KITTITAS VALLEY FIRE & RESCUE

June 24, 2008

I have reviewed the application for the B&J Preliminary Plat (LP-08-21). This information is provided for informational purposes to the developer. During development, the following issues will need to be addressed:

B & J PLAT
PART OF SECTION 7, T. 17 N., R. 18 E., W.M.
KITTITAS COUNTY, WASHINGTON
- PRELIMINARY PLAT -

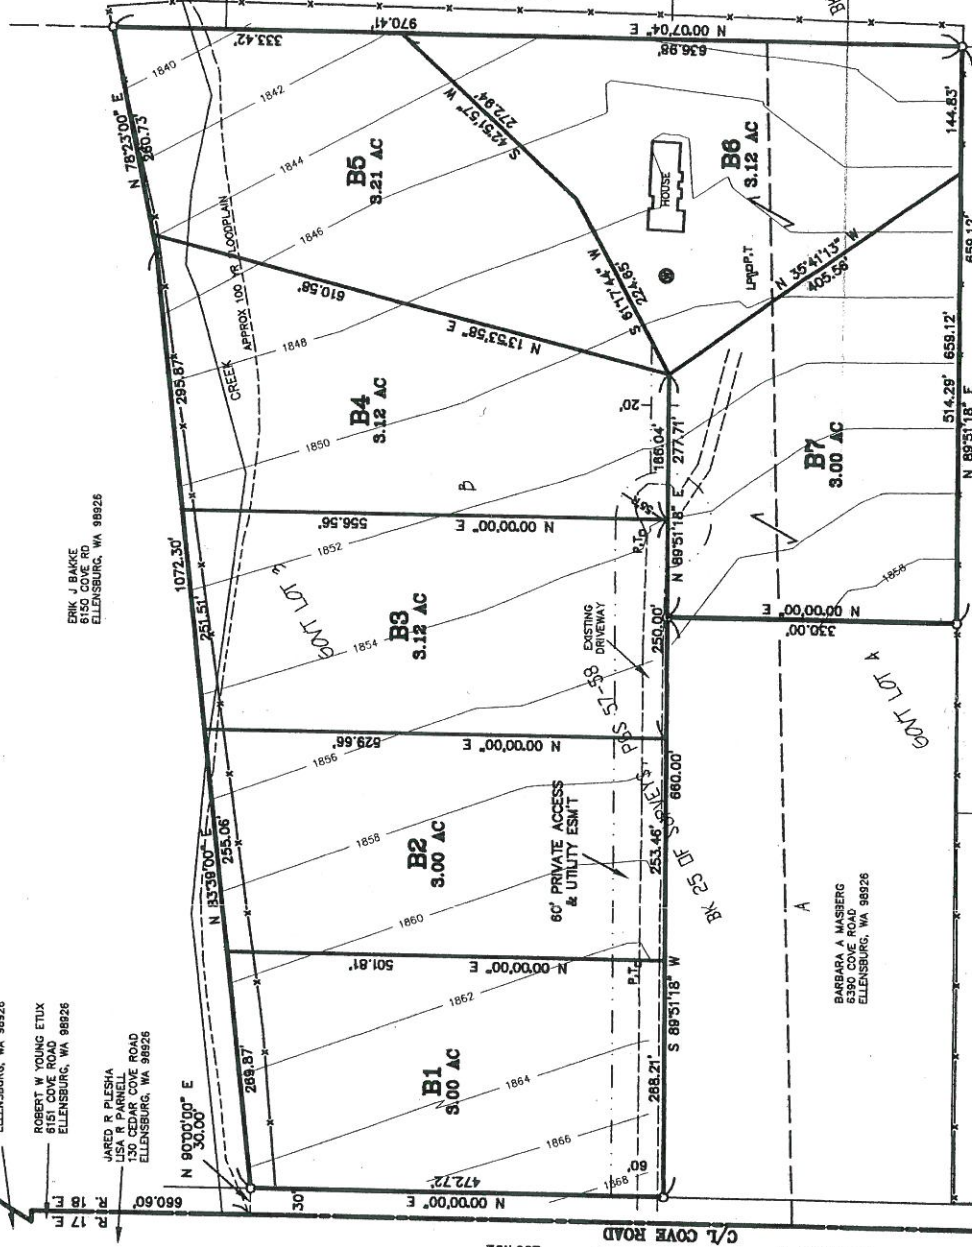
1. The addresses need to be clearly visible from both directions at the county road for all properties.
2. The fire department access road needs to be capable of supporting 75,000lbs in all weather, be 20' wide, provide 13'6" vertical clearance and provide for adequate turn-around for fire department apparatus in accordance with IFC 2006 – Appendix D.
